**Re: Response to Comments**  
**PROPOSED BUILDING EXPANSION**  
**185 RAND ROAD, PORTLAND, MAINE**  
**CBL 254 A007001**

We have reviewed the staff review comments, received July 2 and July 15, and have prepared the following responses to address their concerns. The comments are reiterated in italics for reference with our response, in bold, immediately following:

Sheet Name: SITE PHOTOMETRICS  
Sheet Number:

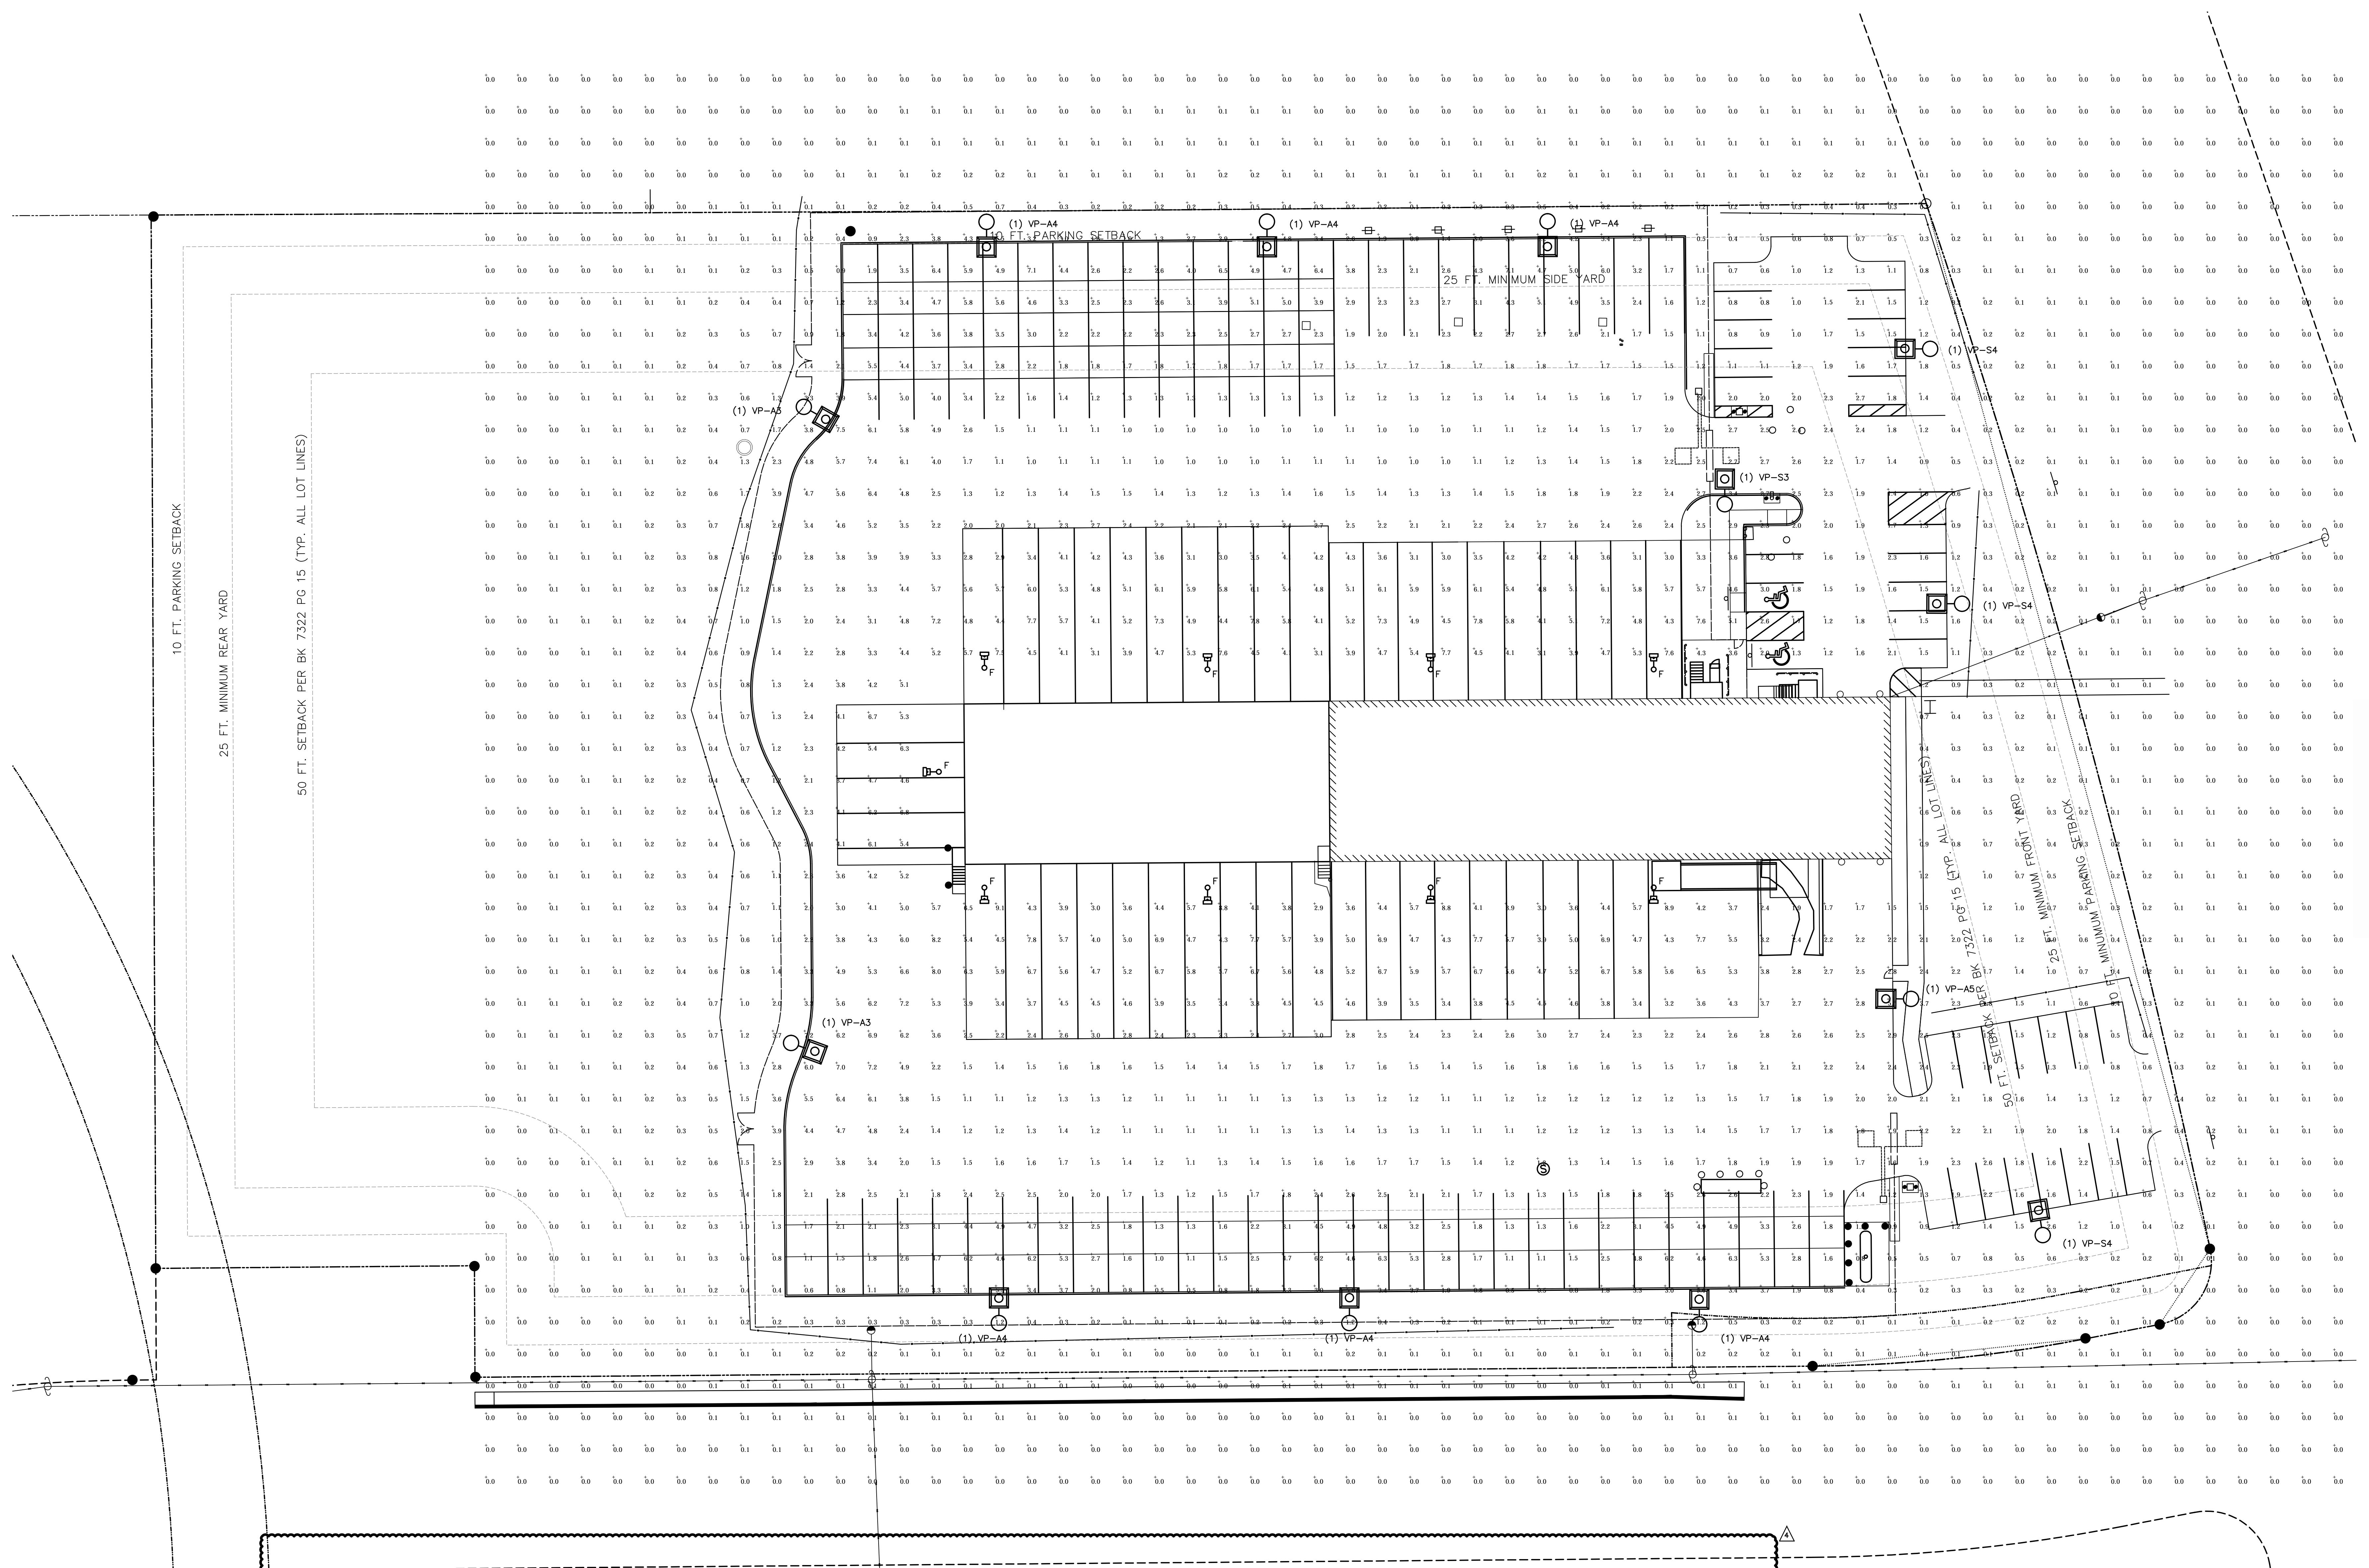
5. *There are revised site plans showing revisions to earlier submitted plans. It now appears that all pavement and parking is located outside of the protected 75' Stream Protection area. There is one light pole that is still within that protected 75'. I find nothing in the ordinance allowing the light pole in the protected 75' without Planning Board approvals. It appears to me that one light pole can be shifted just a few feet to be outside of the protected area. As a note, fences are not considered a structure and can remain in the protected 75' area. We have allowed such fences previously on other site plans.*

**The plans have been revised to relocate the light poles outside of the 75' setback. A revised Photometrics Plan has been enclosed with the plan set.**

FIELD WK: JIM/MC	SCALE: 1" = 30'	SHEET:
DRN BY: RPL	JOB #: 2454	C3
CHD BY: CYN	MAP/LOT: 254/A007001	
DATE: 02/26/14	FILE: 2454-SITE

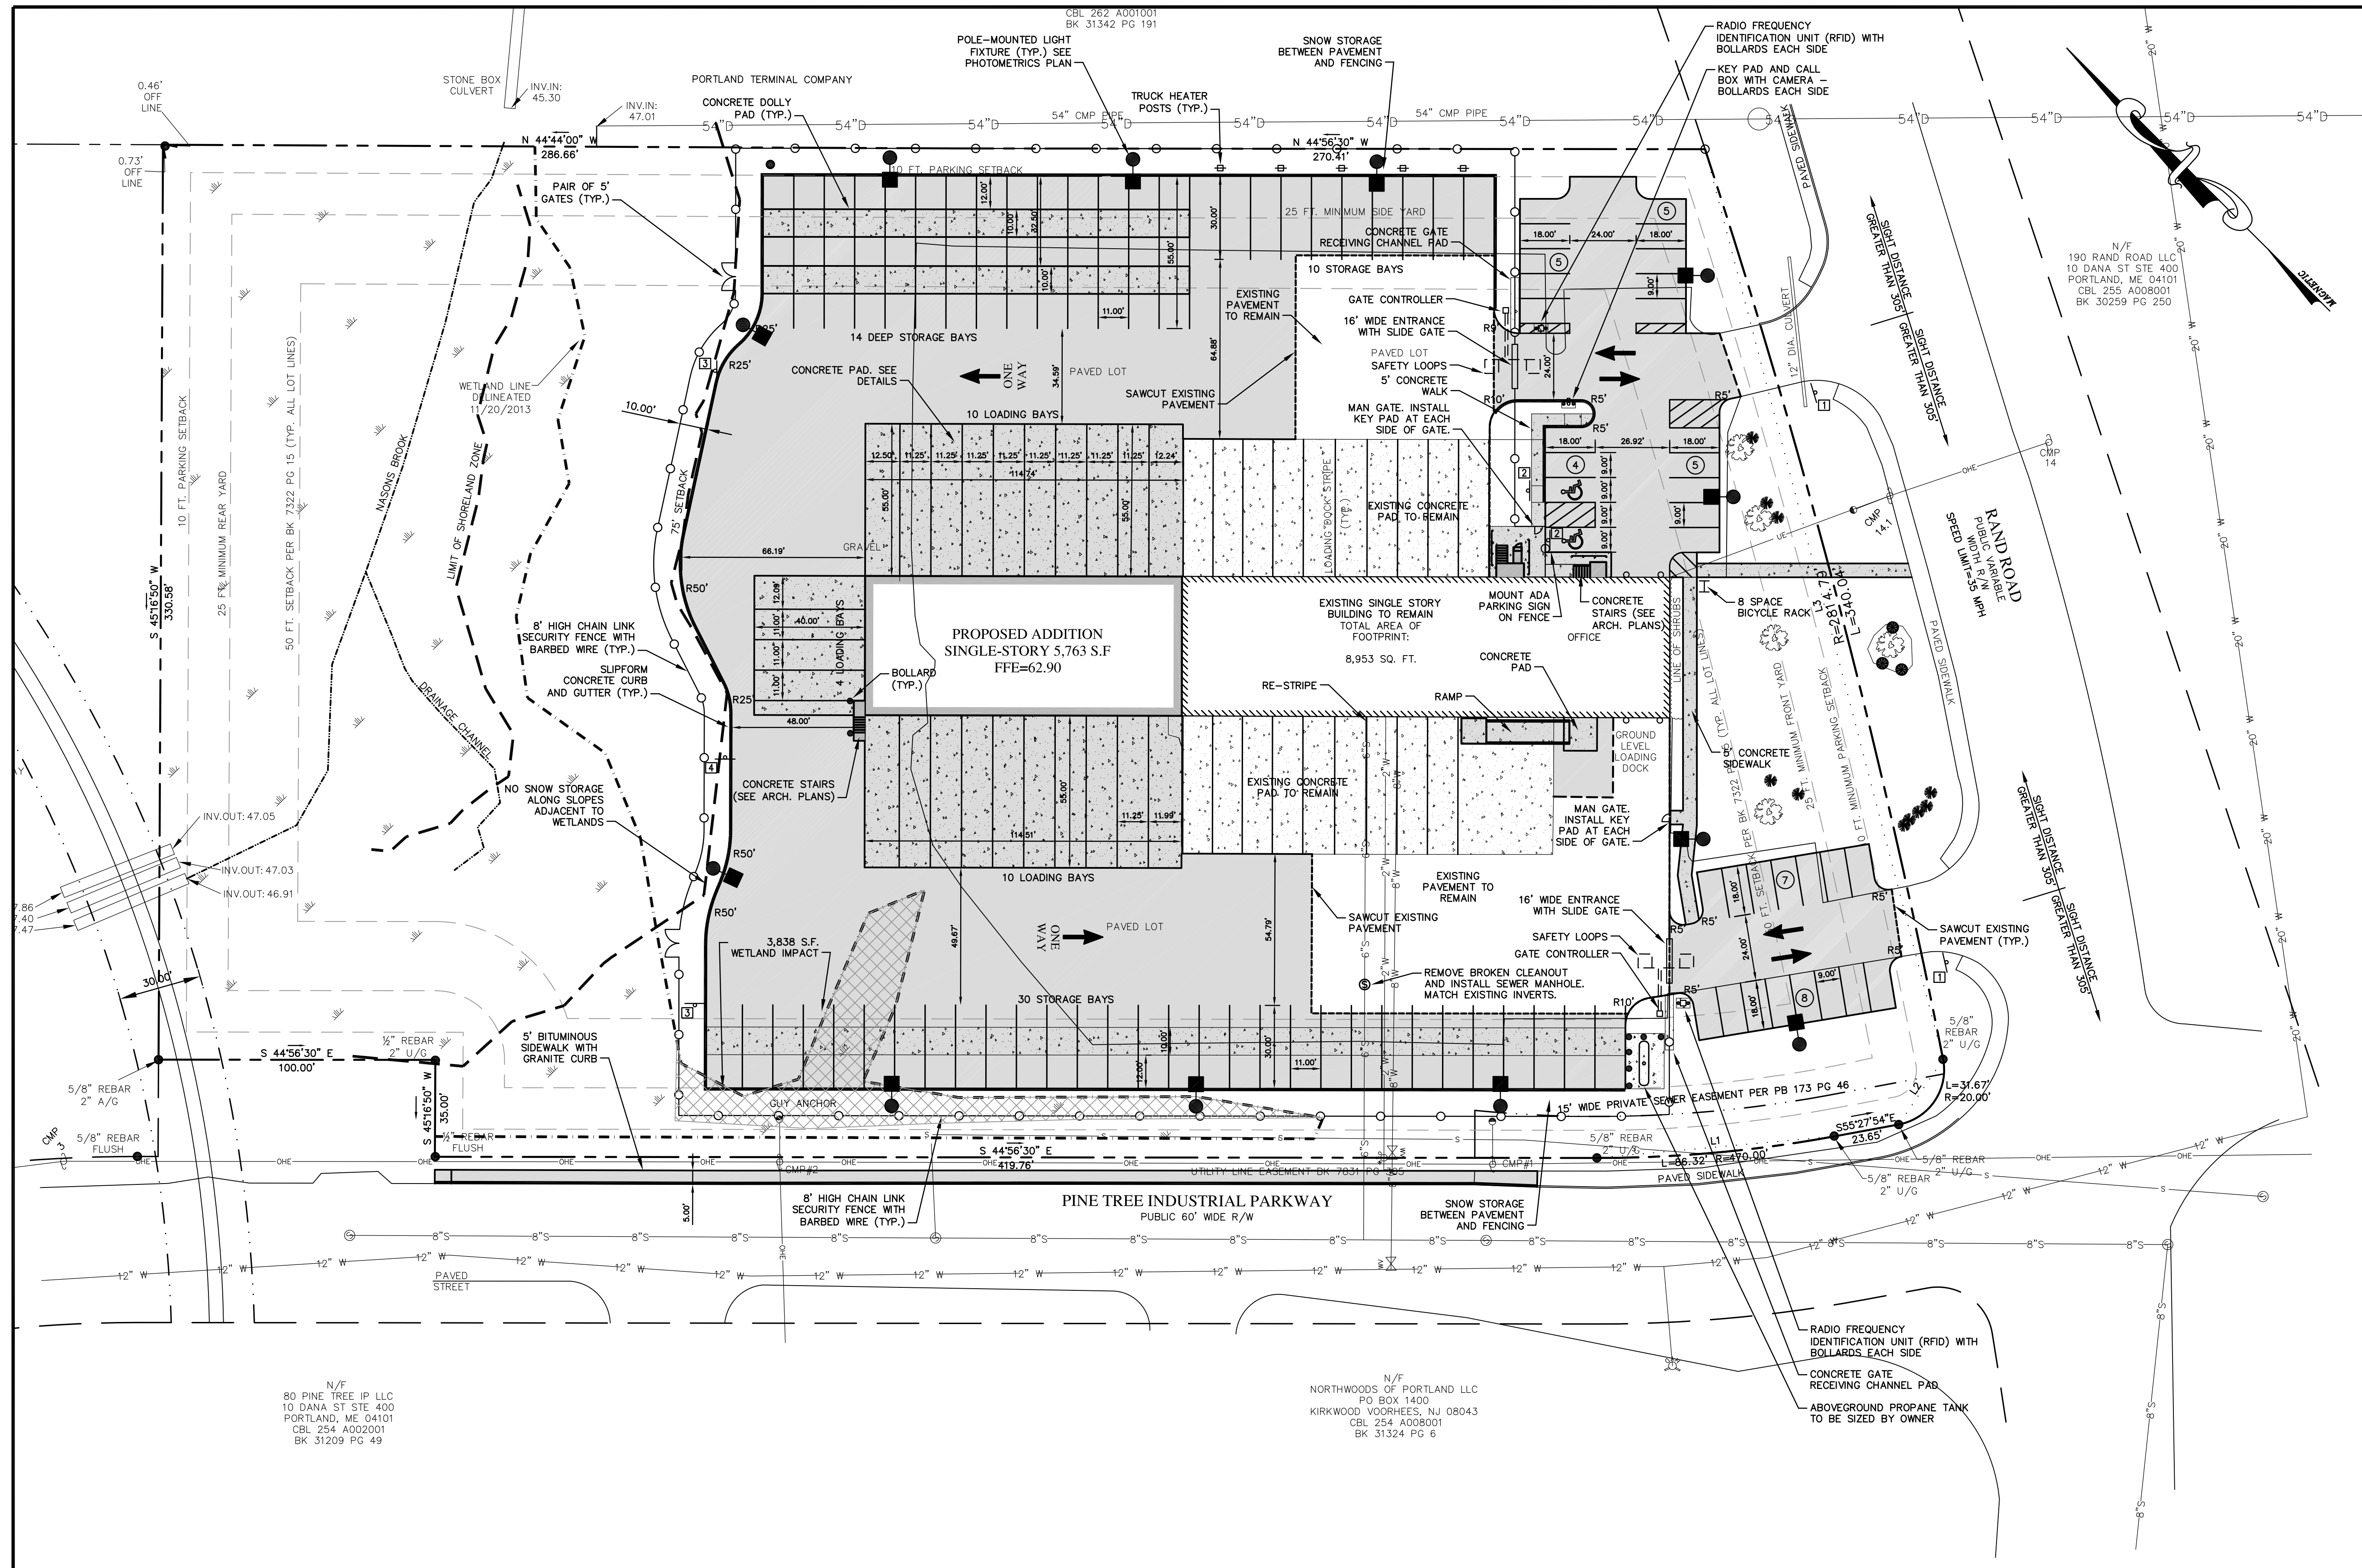
2. *You note that the circulation of the site will be one way but I assume that is only in the gated truck storage/loading area and not the parking lots along Rand, is that correct? If so, could you note that circulation concept on a final plan?*

3. *It sounds like the applicant is willing to construct the sidewalk along the Pine Street Industrial property line, from the existing sidewalk to the end of the property.*

**Yes, this is correct. Pavement arrows and signage will be added to the Site Plan to indicate circulation.**

**Yes, this is correct. As shown on the attached site plan, the sidewalk will terminate at the end of the western property line that directly abuts the roadway. There is a bump-out in the property line, adjacent to the railroad, that appears to be maintained as cleared area associated with the railroad.**

**Due to the grading of the road, a catch basin will need to be added to drain the low point of the road that will outlet to the ditch adjacent to the wetland.**
